D1 Submission: Design Concerns.

D1 Submission: More Concerns.

Illustrative Masterplan
Figure 5.5D: Cable Corridor Option D

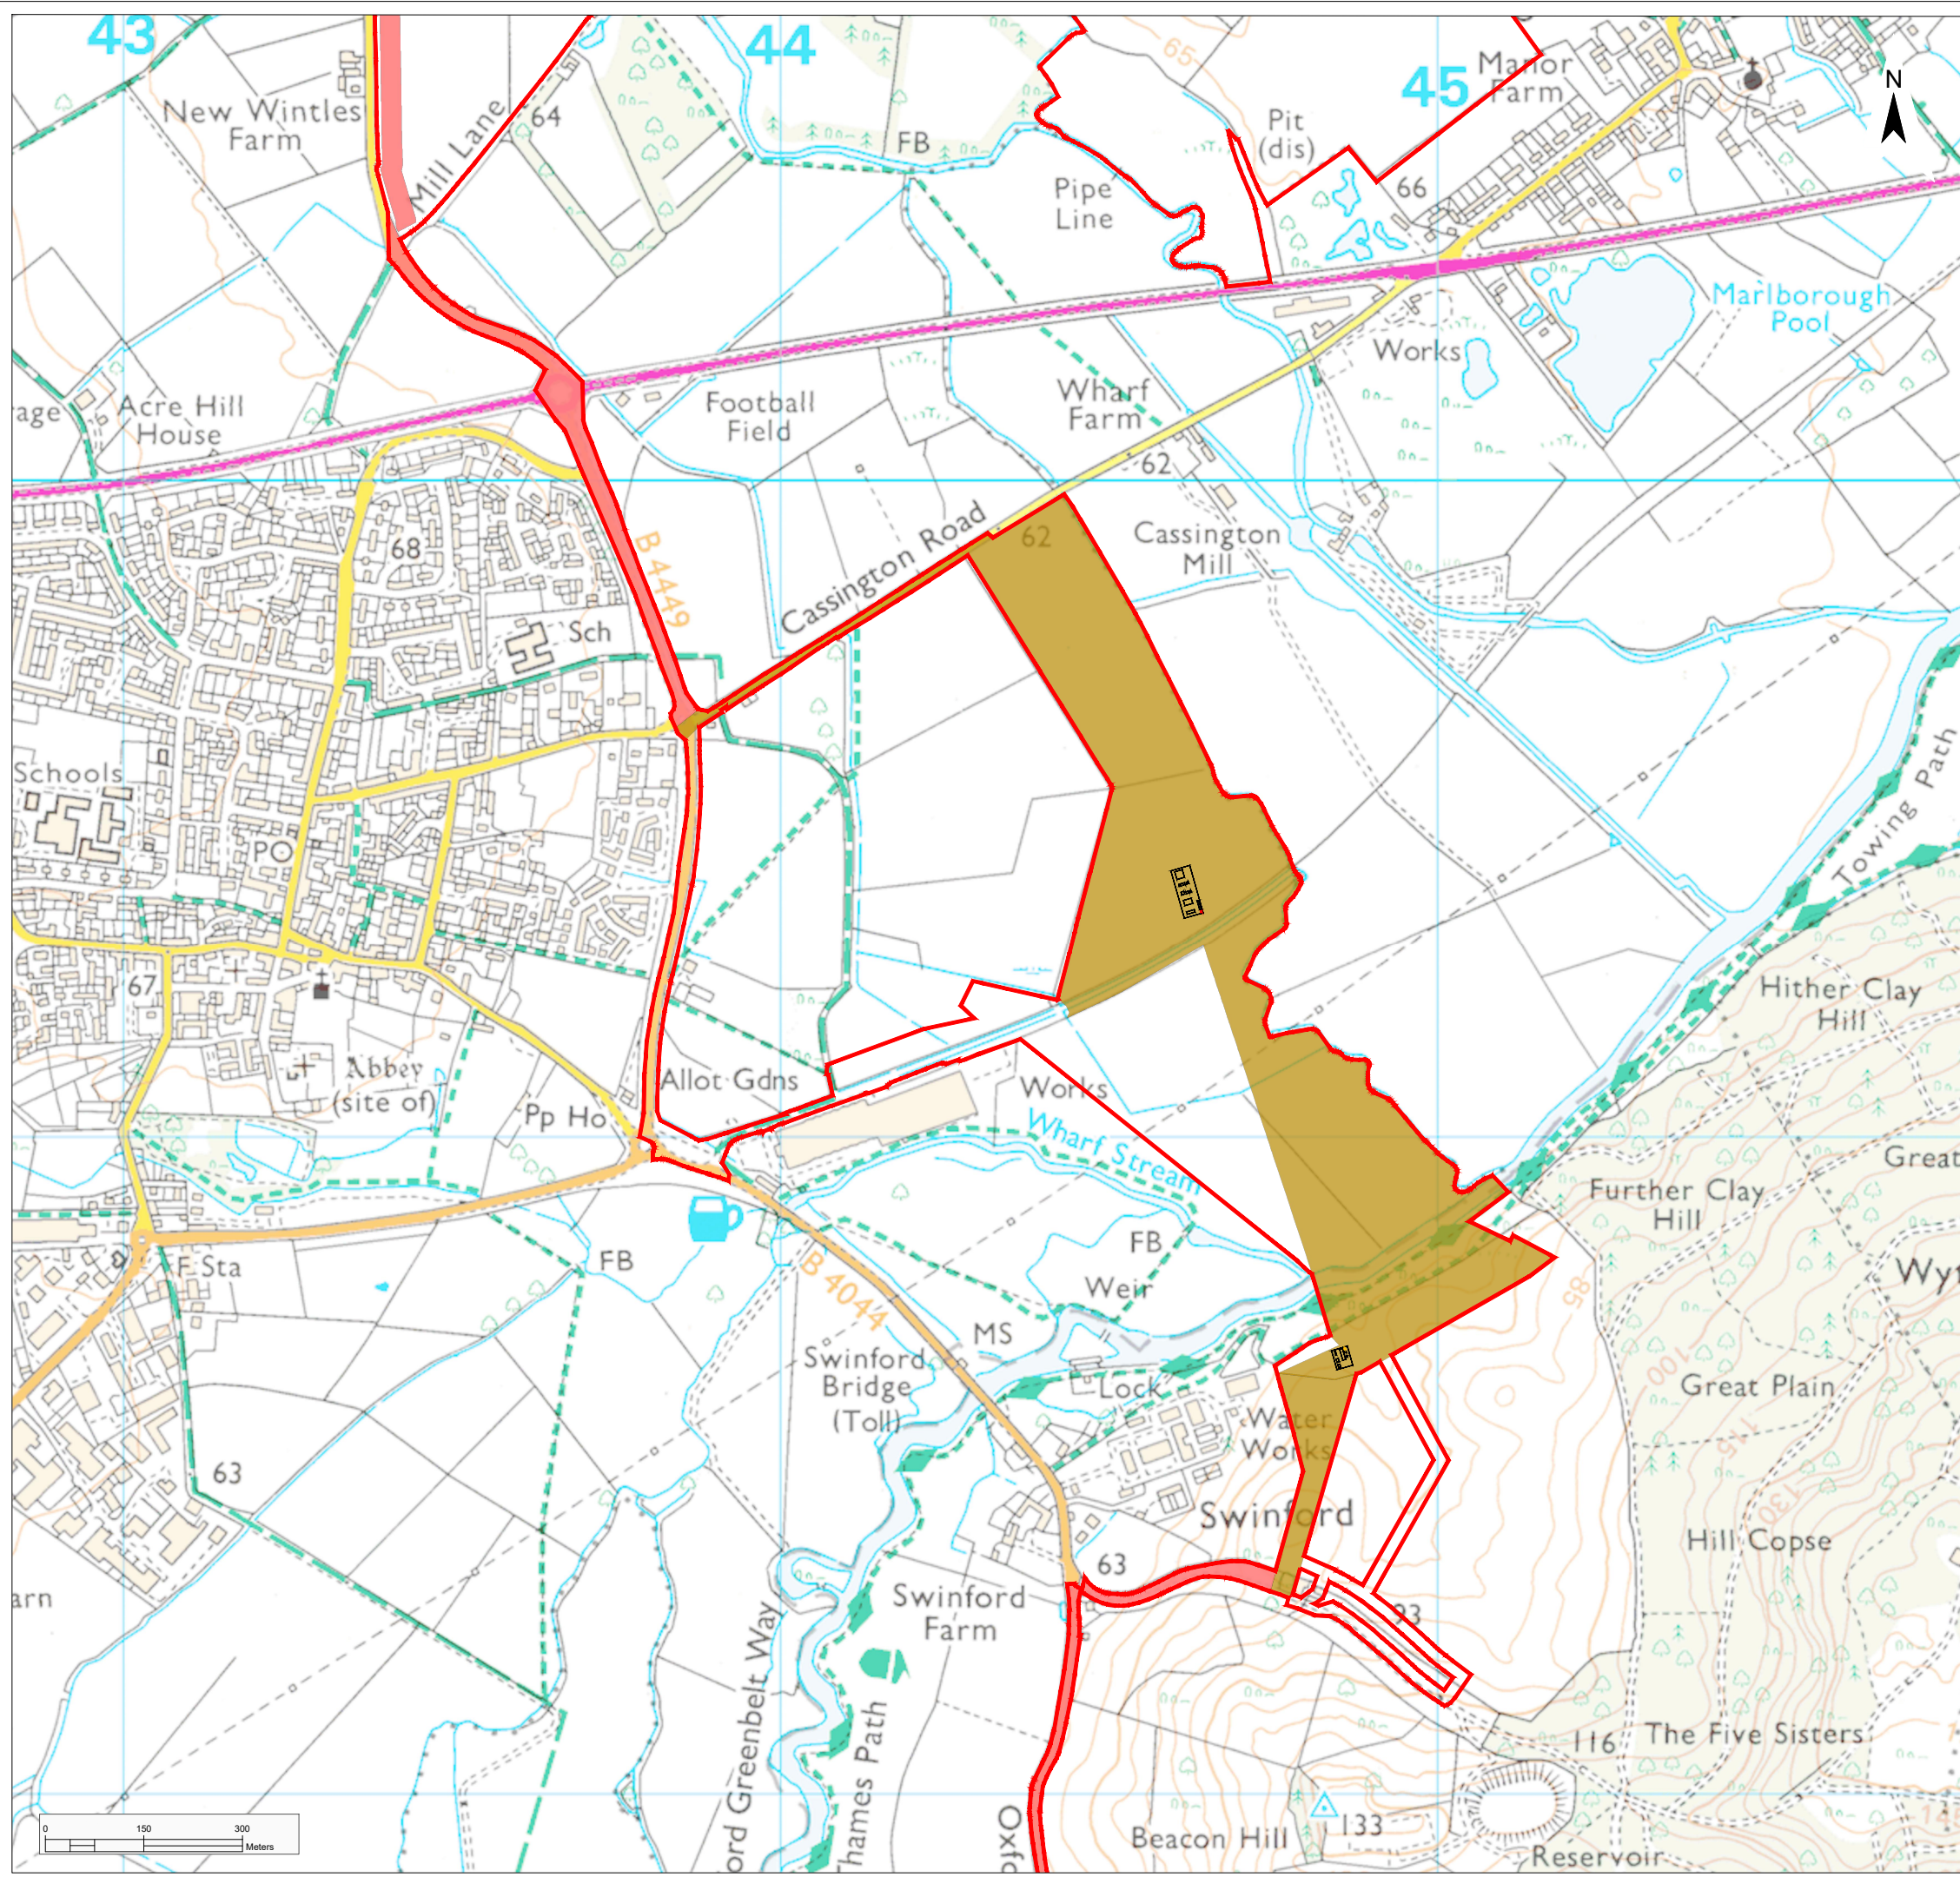
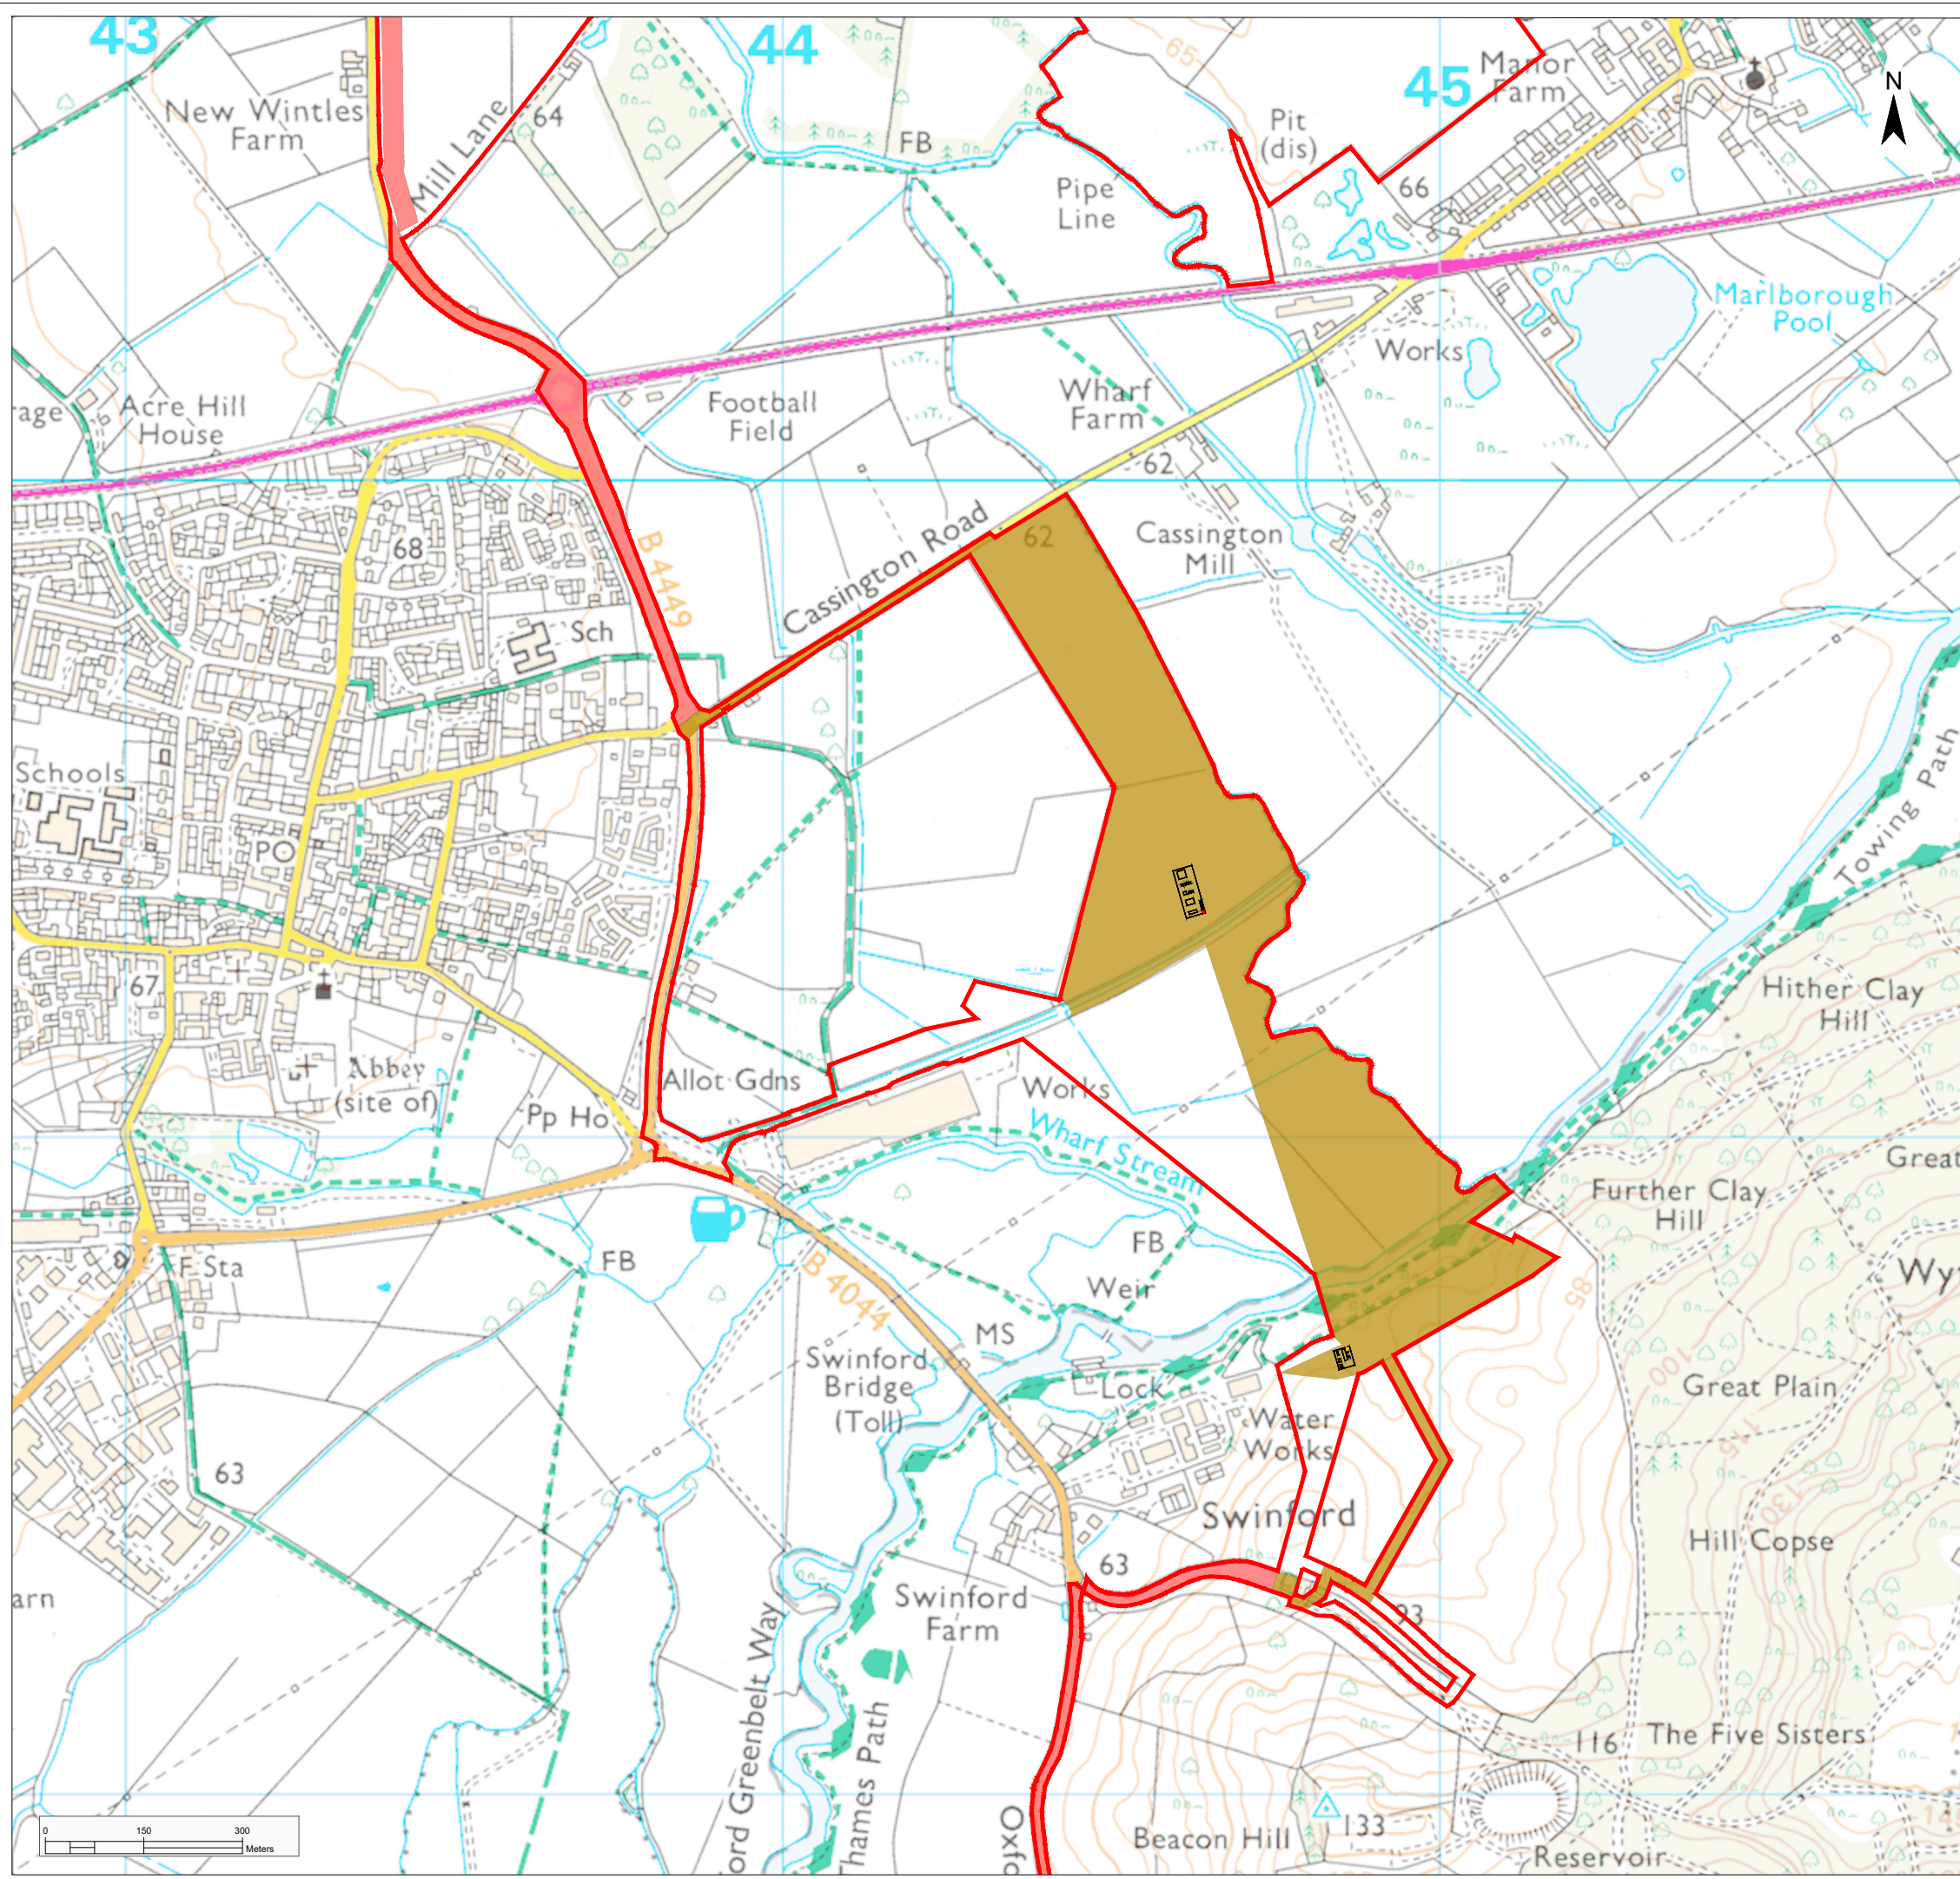
1) There are many ultra-short tables (e.g. **1** and **2** in the diagram). The Scoping Report gave a minimum table length of 14m. Project Description reduced this to 3m. Table **1** looks like a single panel width: 1m.

2) The Masterplan also shows the network of roads (**R**) than run around the perimeters and across the fields. These are coloured grey here but are described as 'grass with occasional matting' or 'natural ground surface' [[OOMP](#), p6]. Are these sufficient to support the weight of emergency fire tenders year-round? Has Oxfordshire Fire and Rescue been consulted? The roads look a bit narrow for the job (2.5m), and the turn radii are certainly far too tight to be negotiated by a fire tender. Should some panels be removed to relax the radii?

3) The north-south table gap is specified in Project Description as between 1.5m and 3.0m; the gaps measured on the Masterplan are 1.5m (panel:gap ratio 3:1).

4) Similarly, Table 6.3 of Project Description specifies a minimum distance of 7m between the fencing and the solar tables, whereas the Illustrative Masterplan shows PV panels consistently packed in with a fence separation of less than 5m.
